Date: 25-Jan-2021
Our Ref: 2020/94403

**Non material amendment to previous permission 2015/92476 for erection of three
detached dwellings**

**Land at, Old Lane/Taylor Lane, Scapegoat Hill, Huddersfield, HD7 4ND
Application Number: 2020/94403**

Proposed Residential Development at :-
Scapegoat Hill, Golcar.
Plot 2 - Layouts - First Floor and Roof Plan.

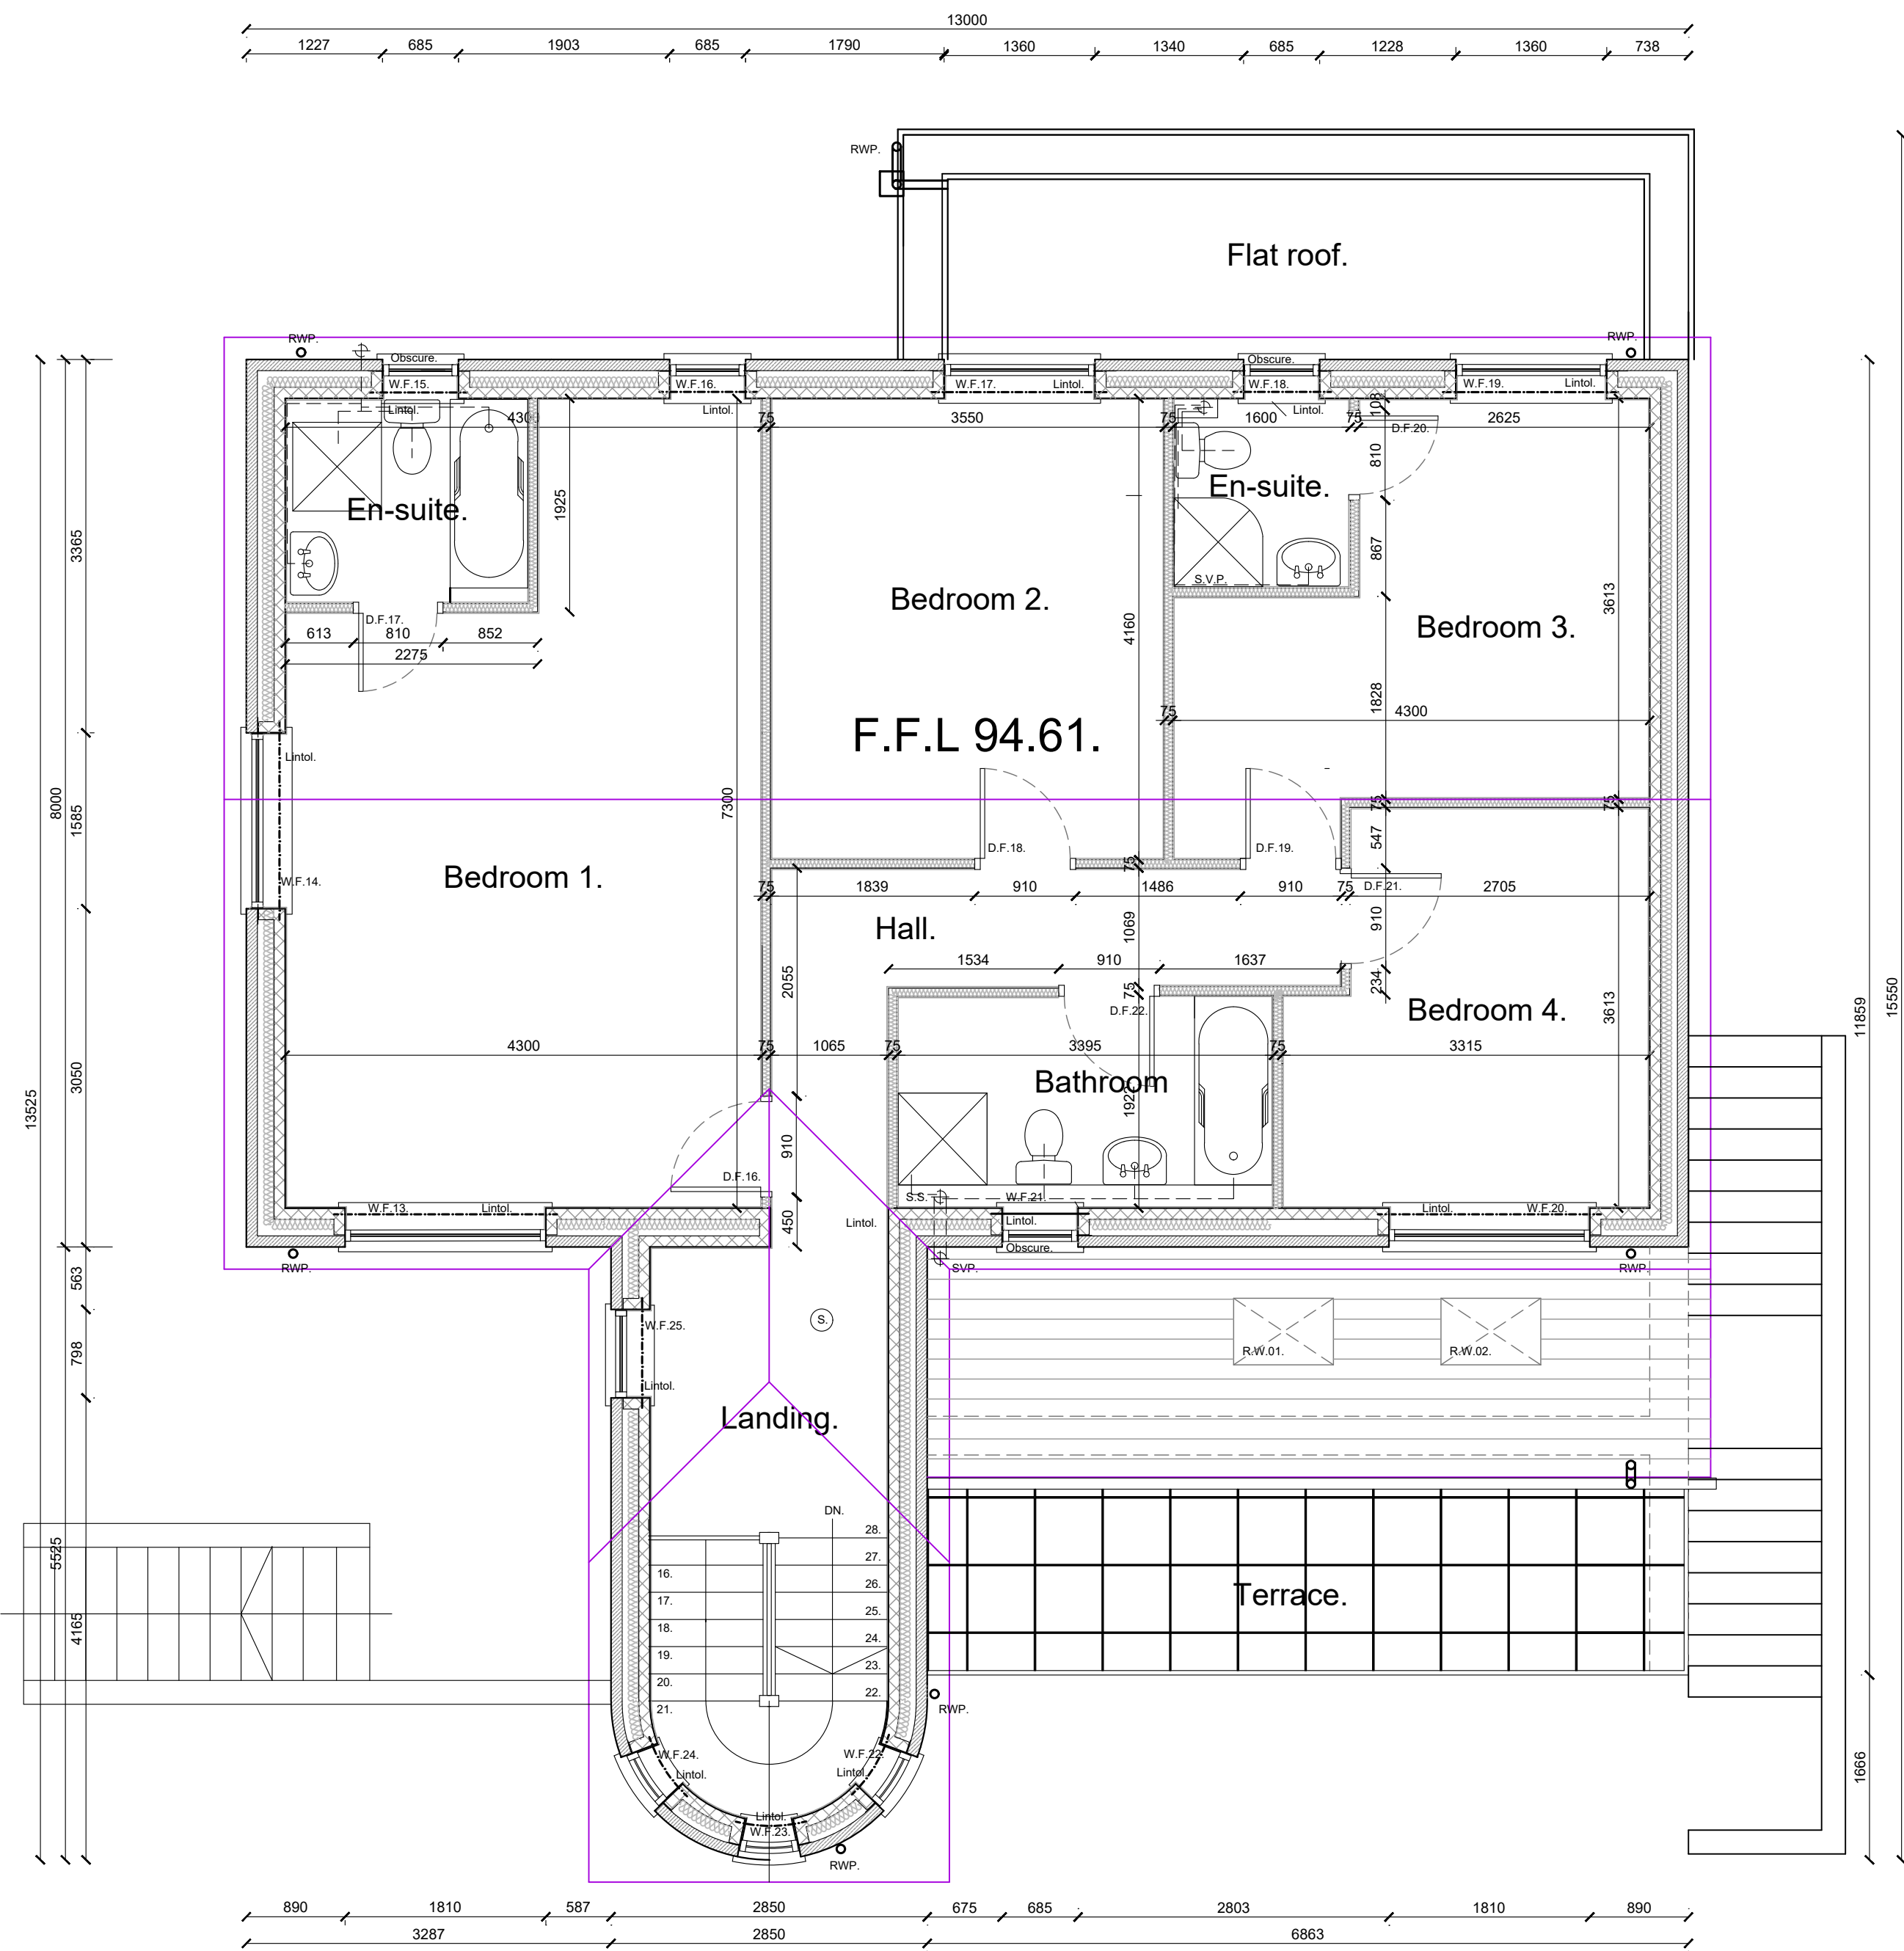
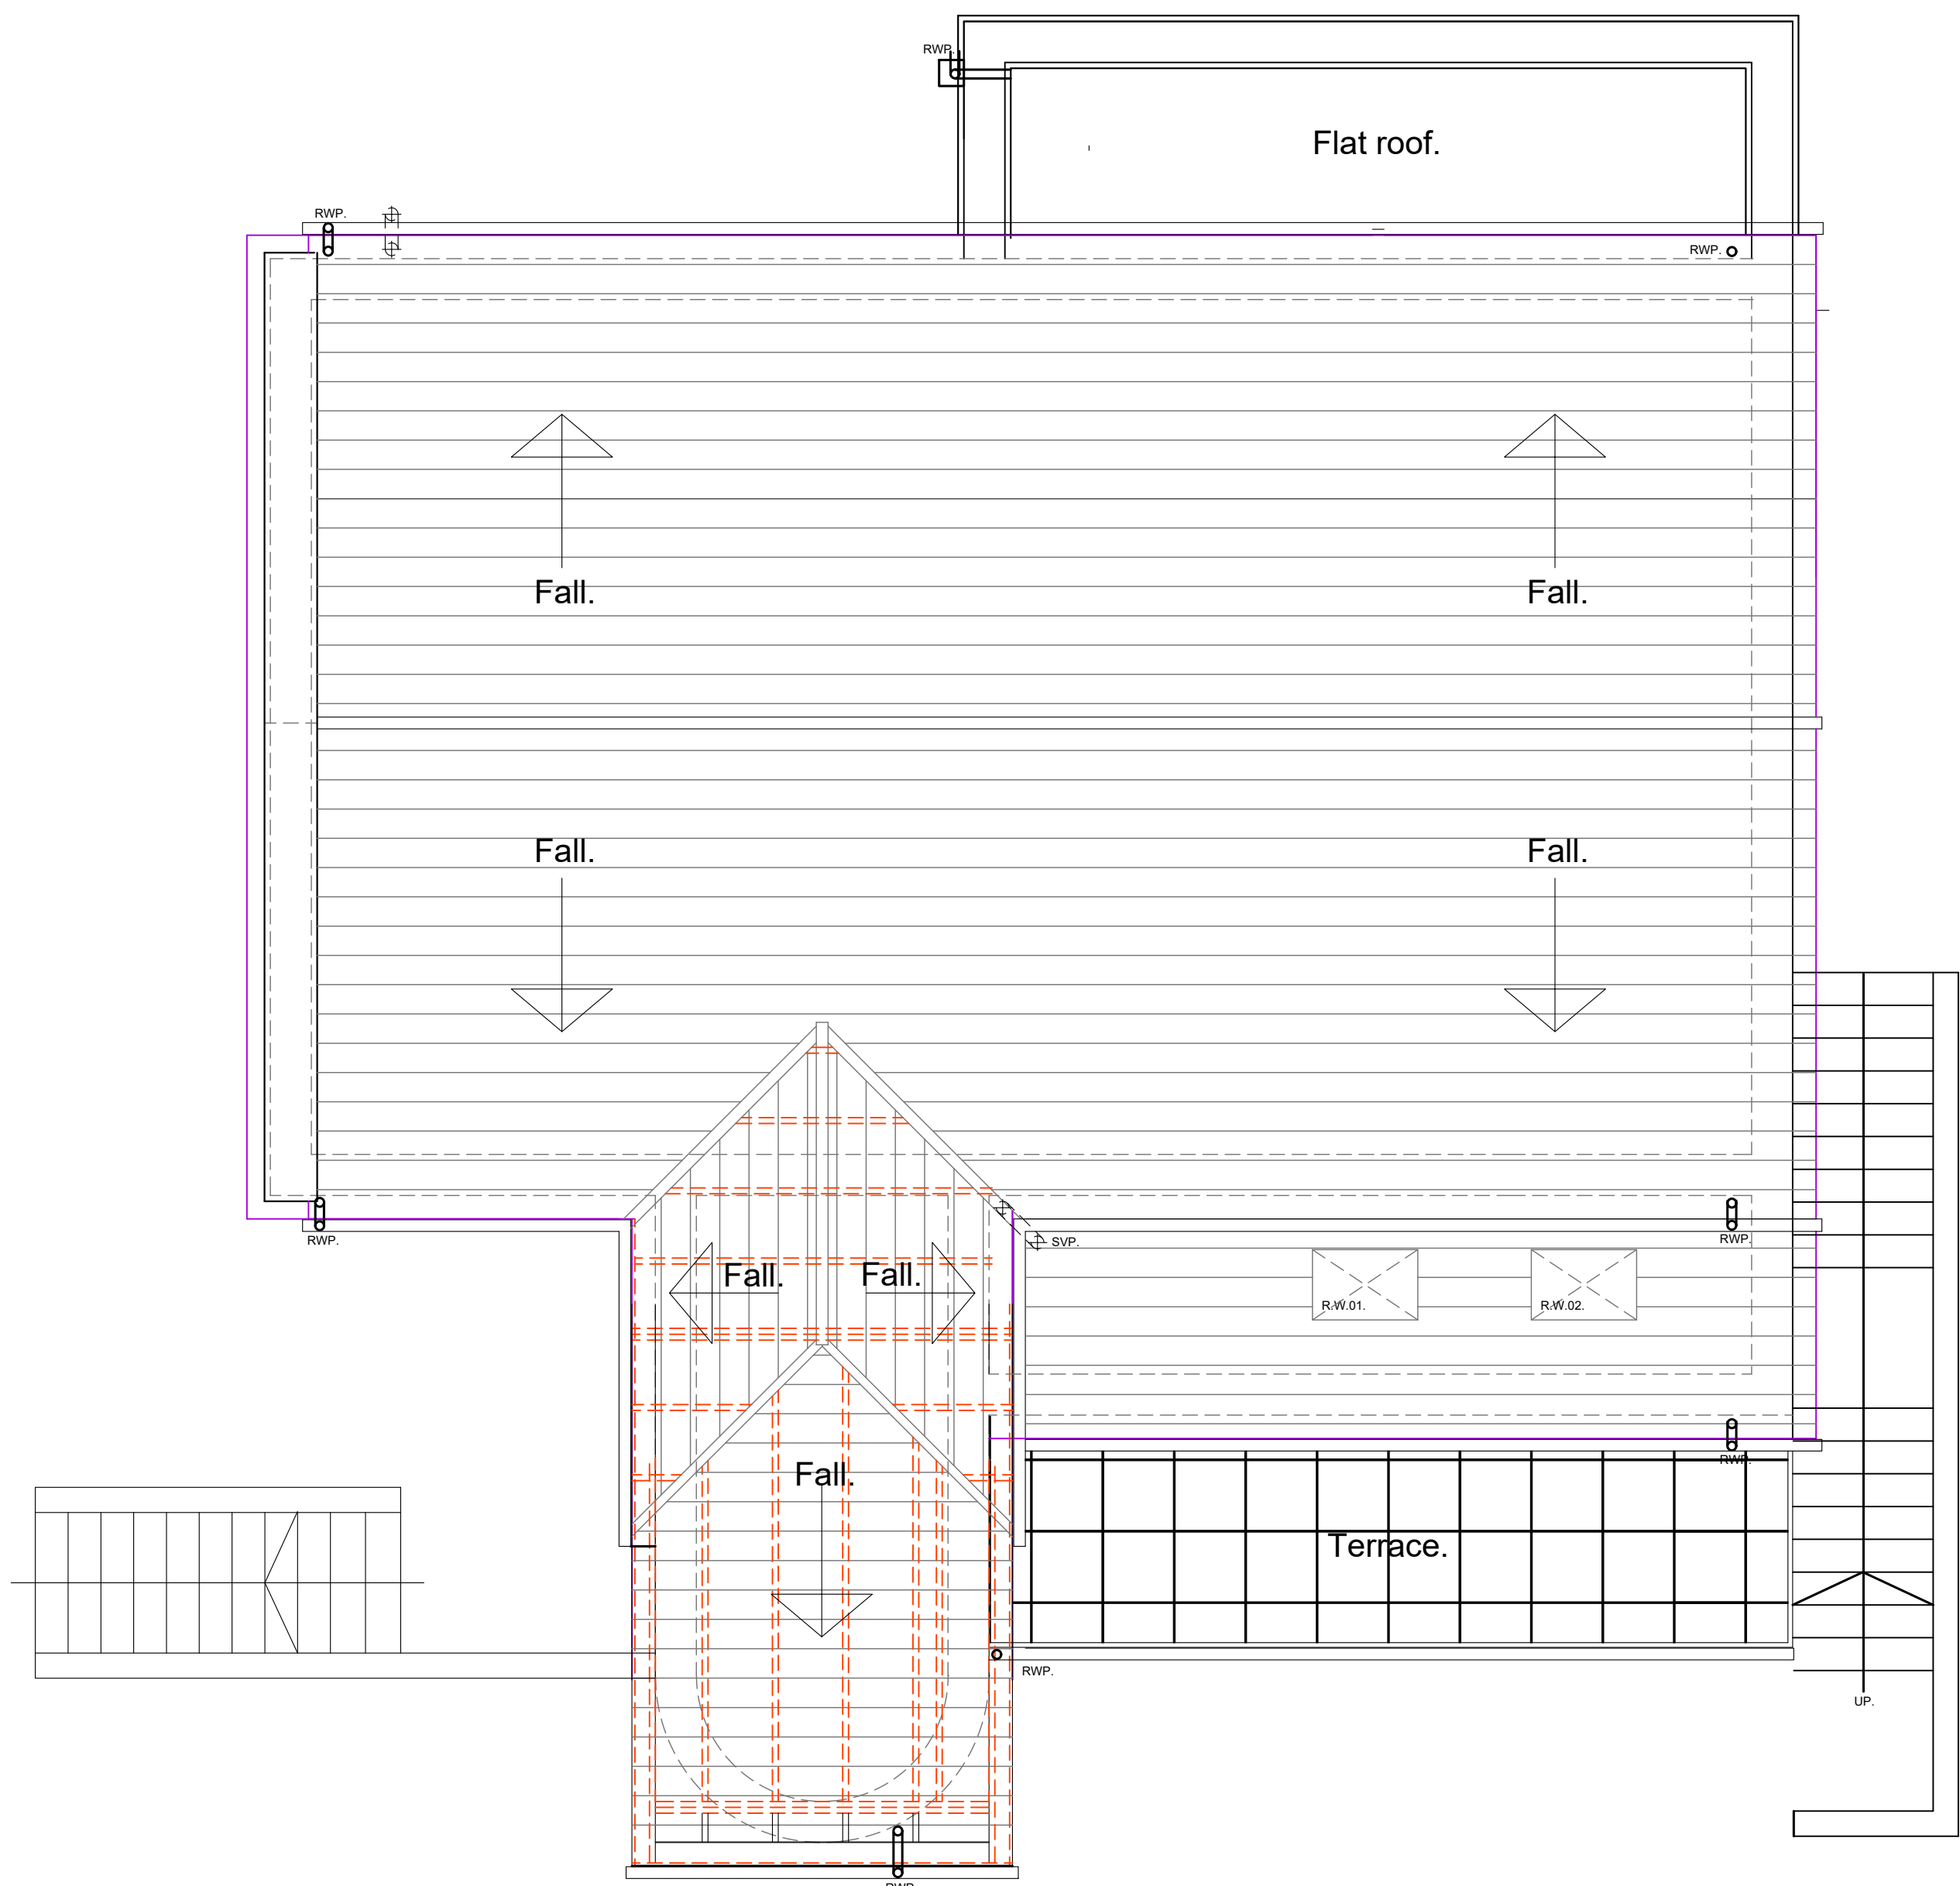
Having compared the approved plans under the 2015/92476 application to those in which have been submitted as part of this application, it appears that significant changes to the overall height, design and form of plot 2 are being proposed. This would result in a material and visual change to the scheme and therefore a new application would be required.
